Ref: APP/2023/1823

Full Planning Permission for Erection of Garage and Ancillary Accommodation at Twelve Oaks, Premnay, Insch, AB52 6PS

Drawing Number  
 2326-P-004

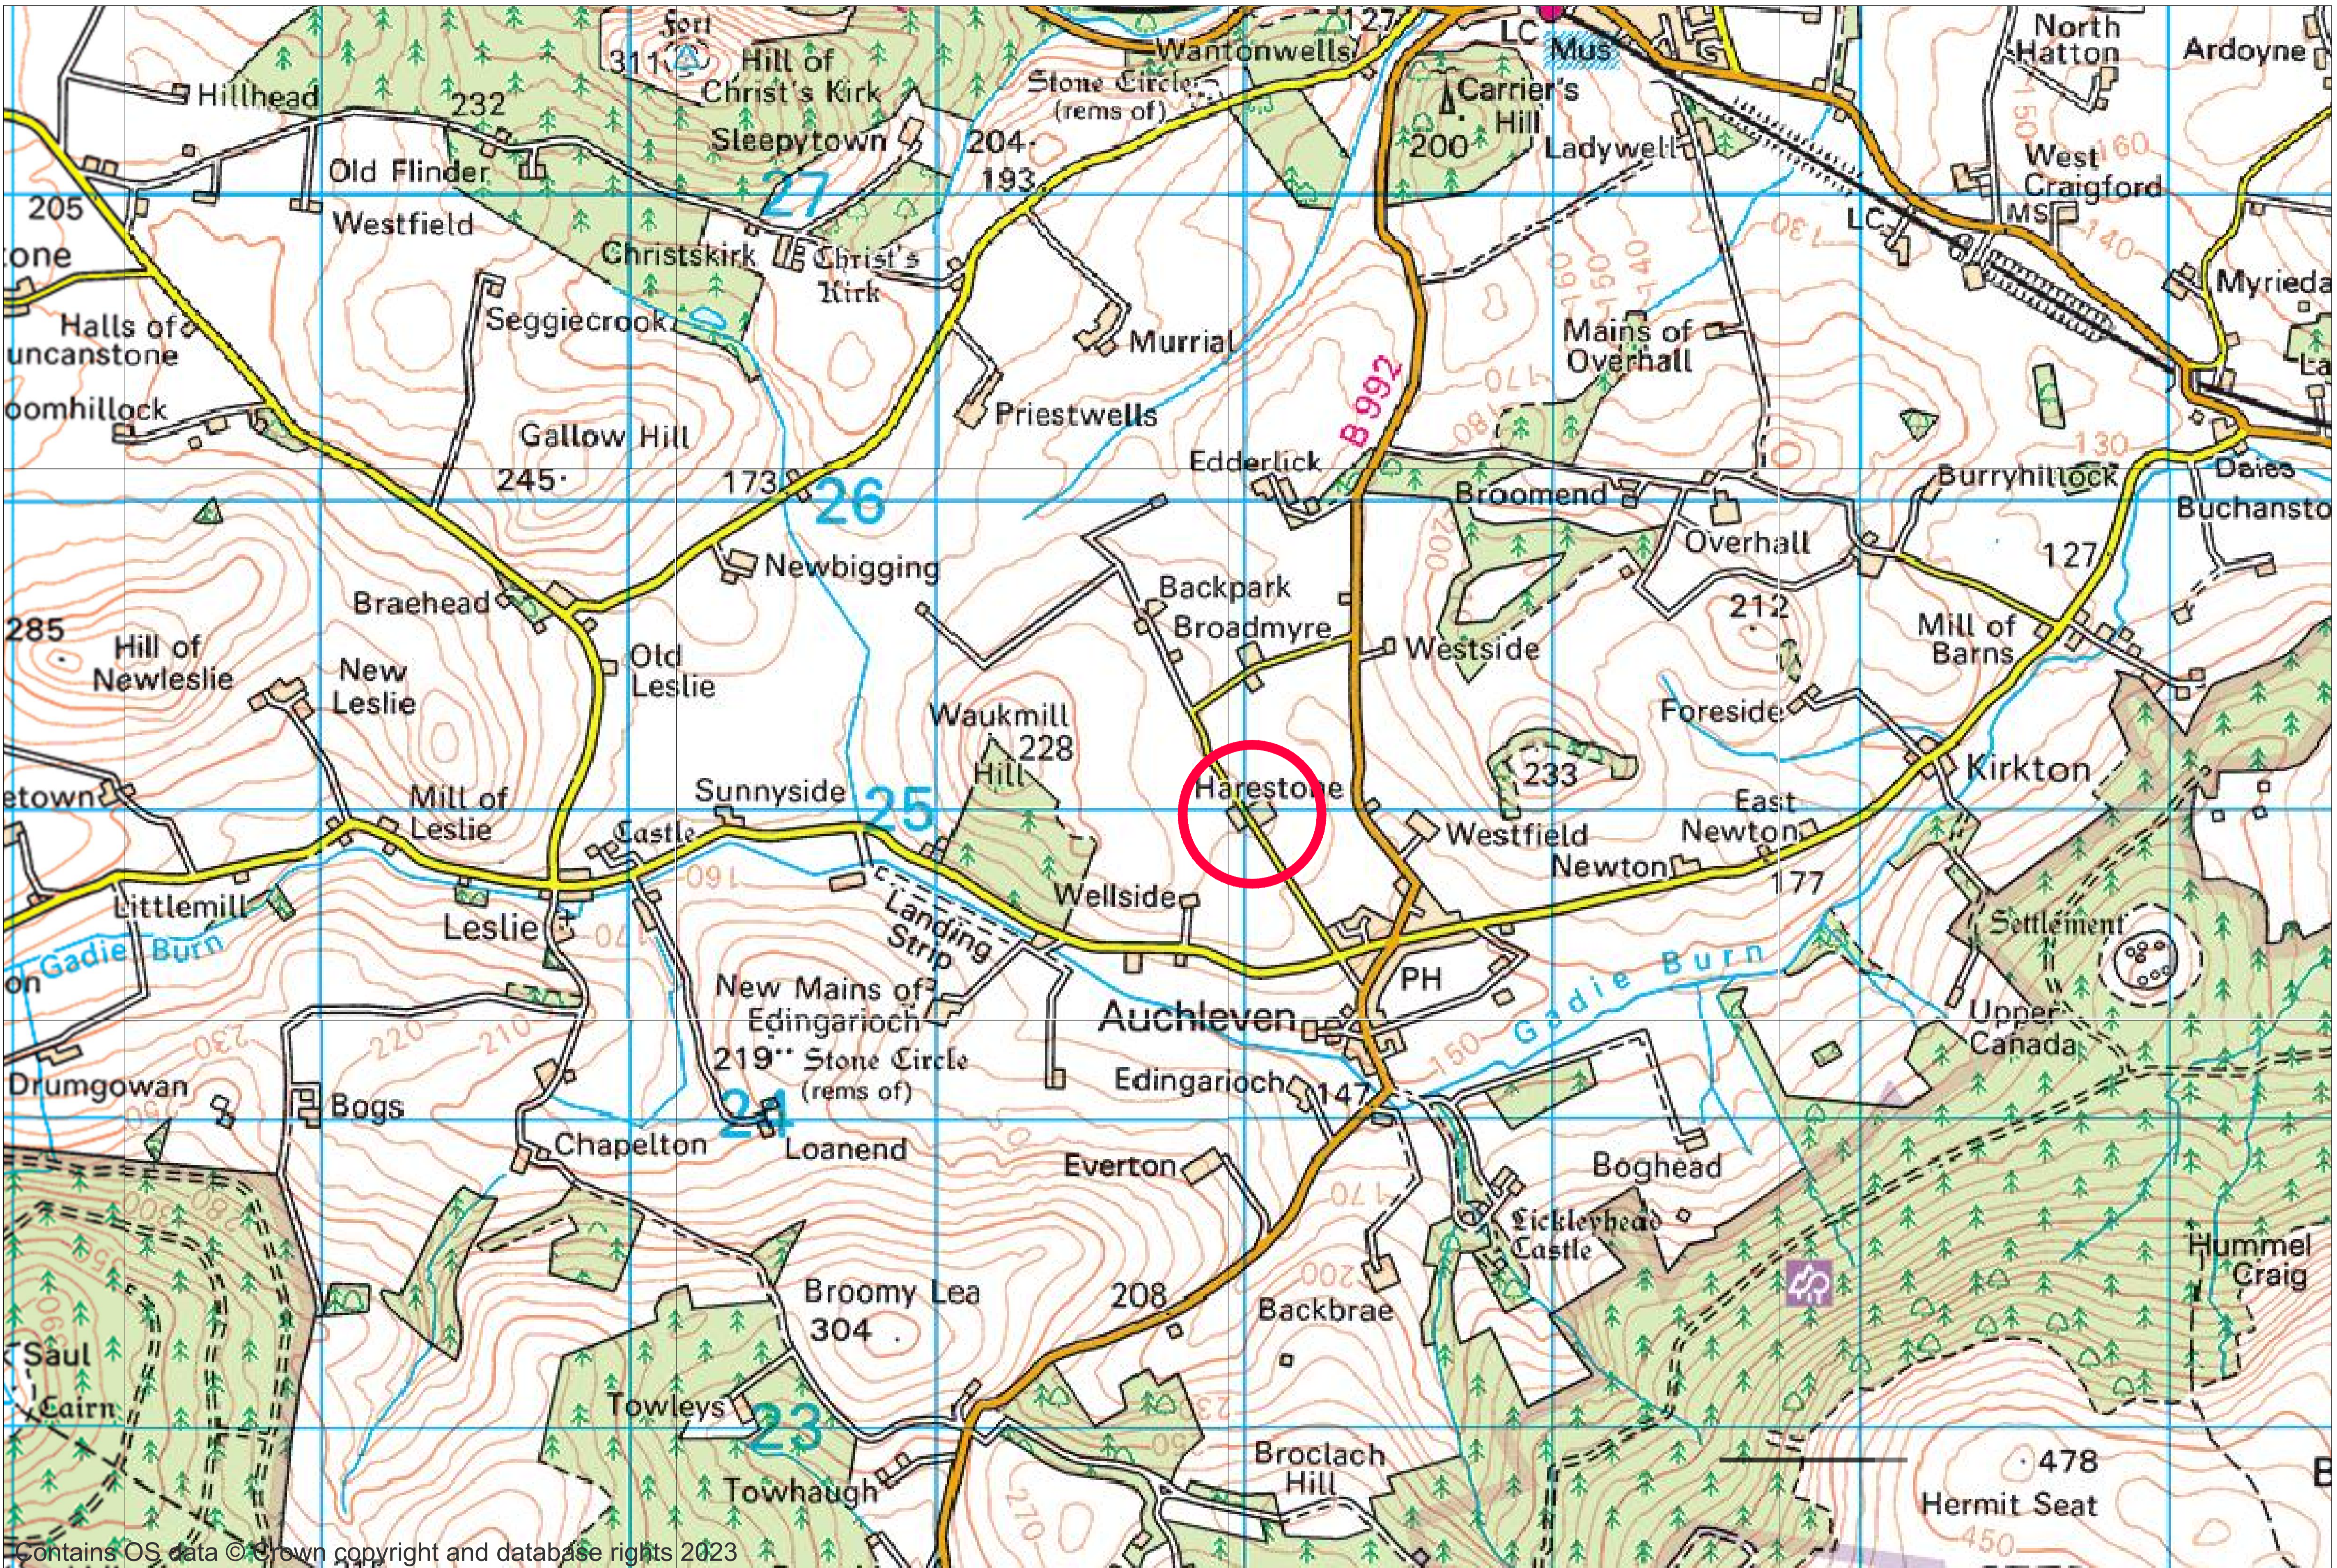
2. Submit an existing site plan.
See dwg. 2326-P-005.
3. As the site is in the countryside please submit an Ordnance survey plan at a scale of 1:10,000 (or appropriate) showing the site in relation to the nearest settlement or popular landmark, this is required for both members of the public viewing the application and members of Council staff who undertake site visits.
See dwg. 2326-P-004.
